OFH1 question

**FIGURE TITLE**  
Indicative BESS and Solar Station Layout

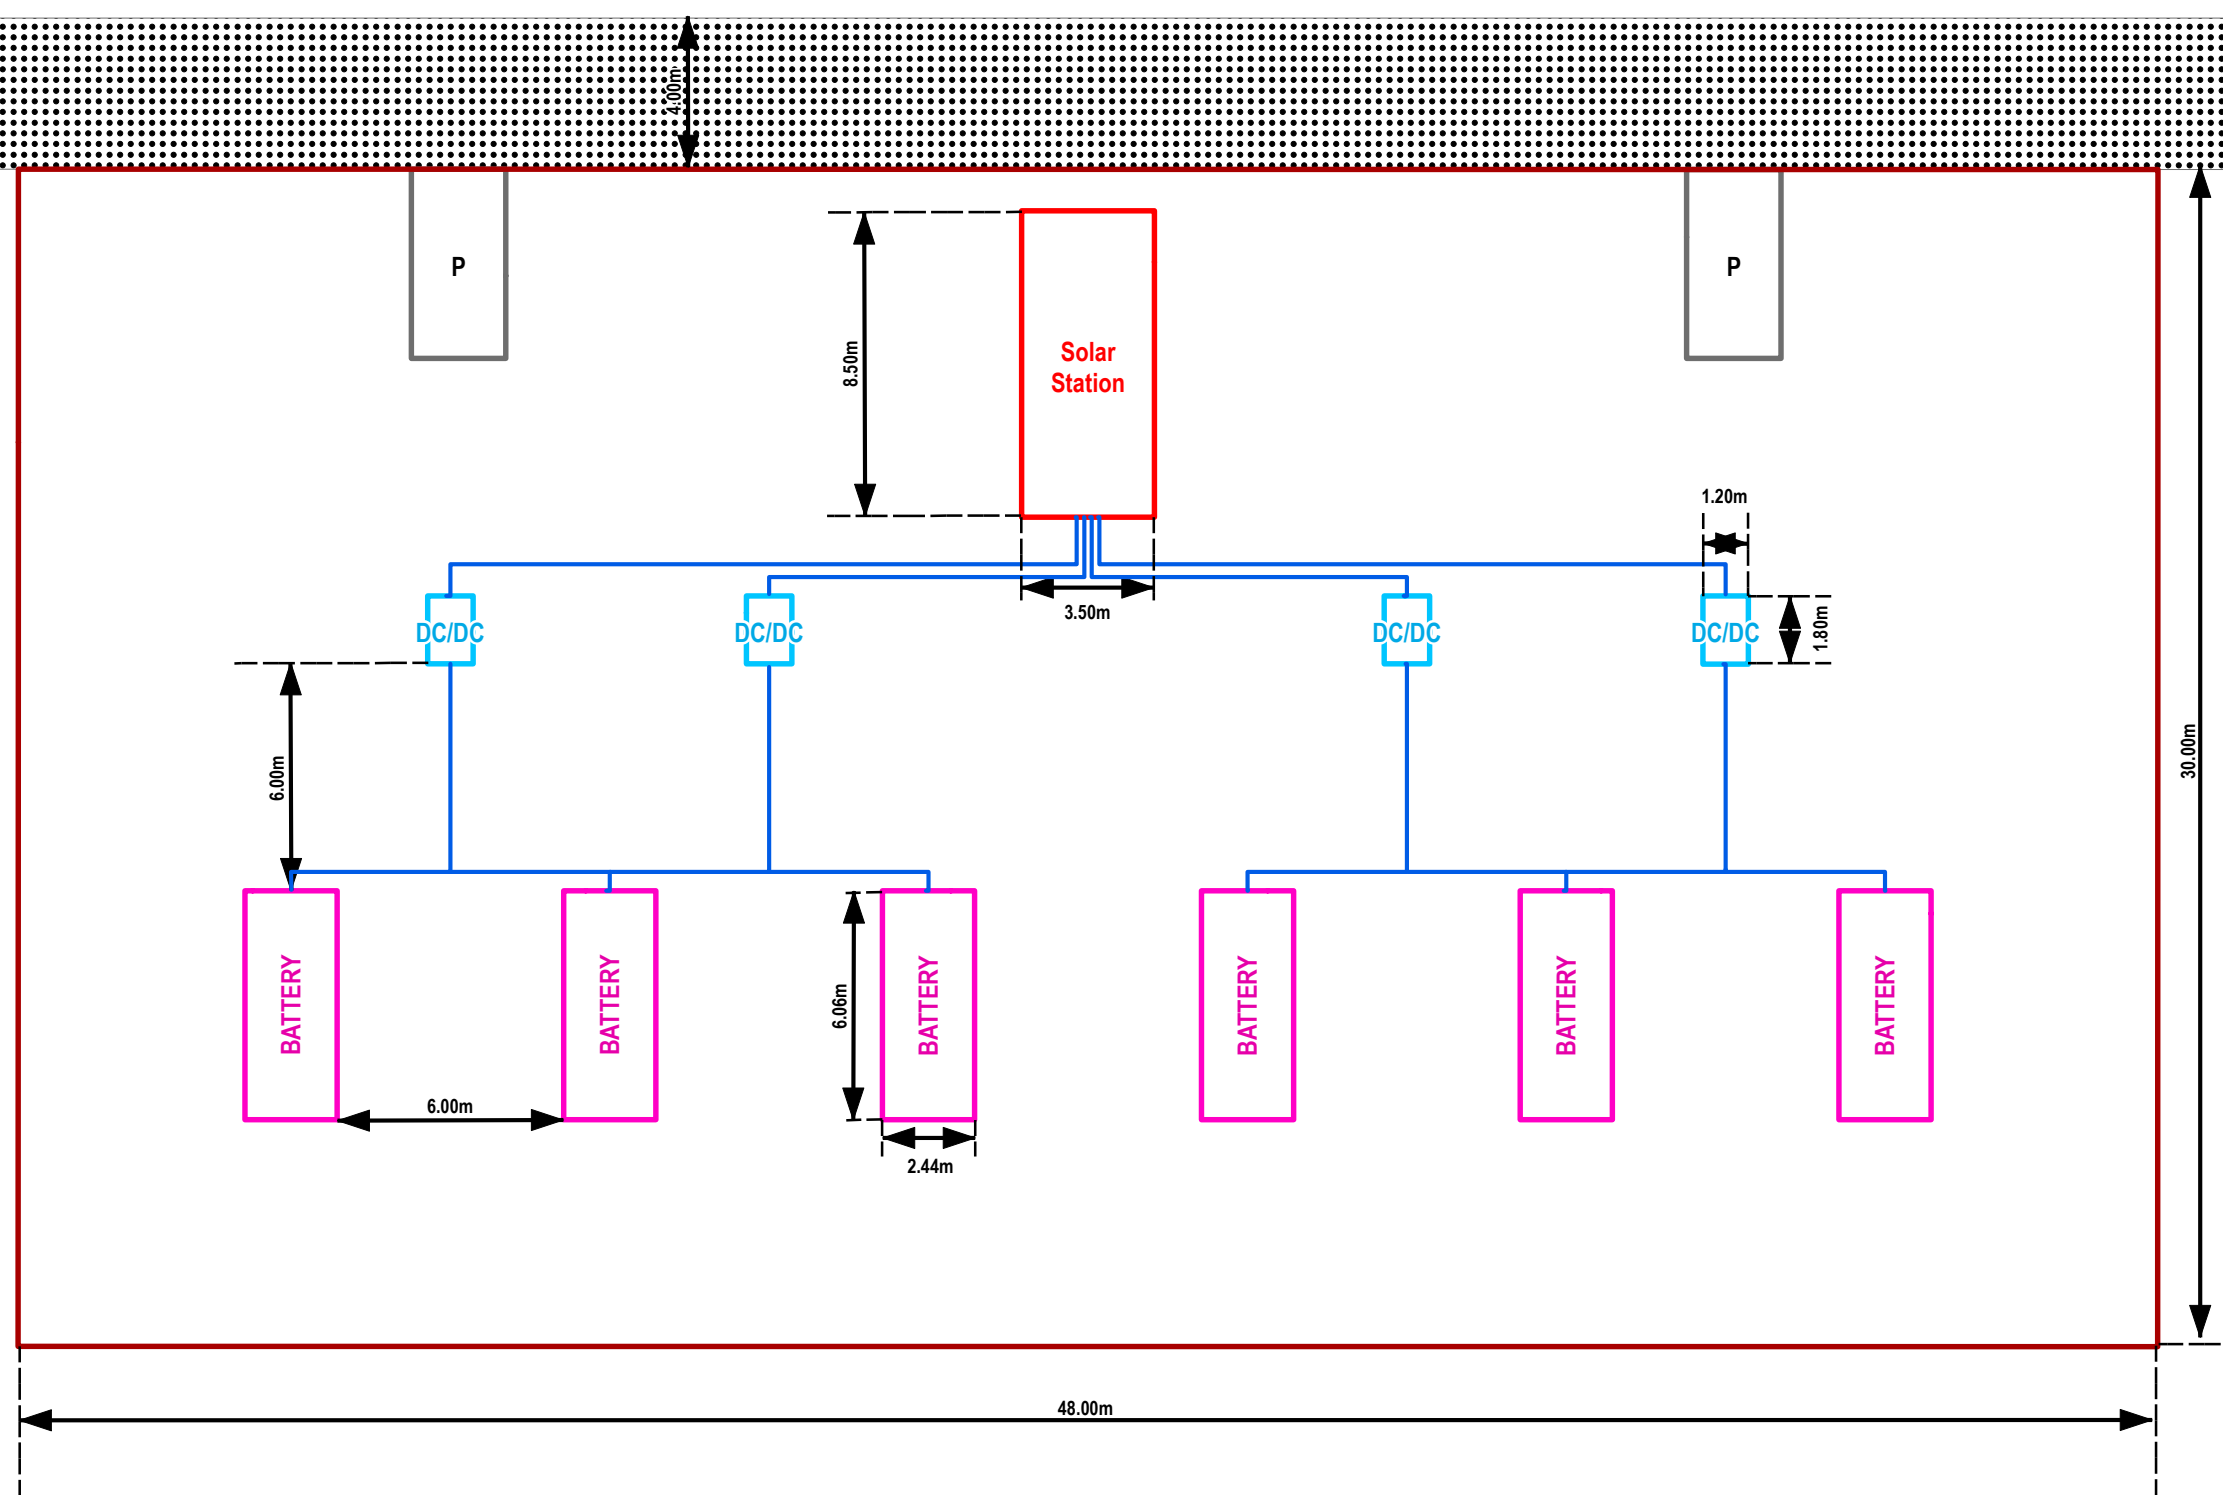
A considerable element of the applicants submissions quote benefits expressed as percentages of power generation, carbon dioxide reductions and population that the electricity generated can support. However within the submissions there is no mention of the specific equipment that the design has been based upon. Whilst I understand that the actual equipment will only be decided upon in the detail design phase, the applicant must have assumed a certain equipment selection in order to generate their statistics.

I therefore request that the applicant provides us with a comprehensive equipment list covering such items as solar panels, BESS battery units, inverters, transformers etc identifying manufacturer, model number and quantities of each so that the statistics that they are quoting can be verified and challenged if appropriate.
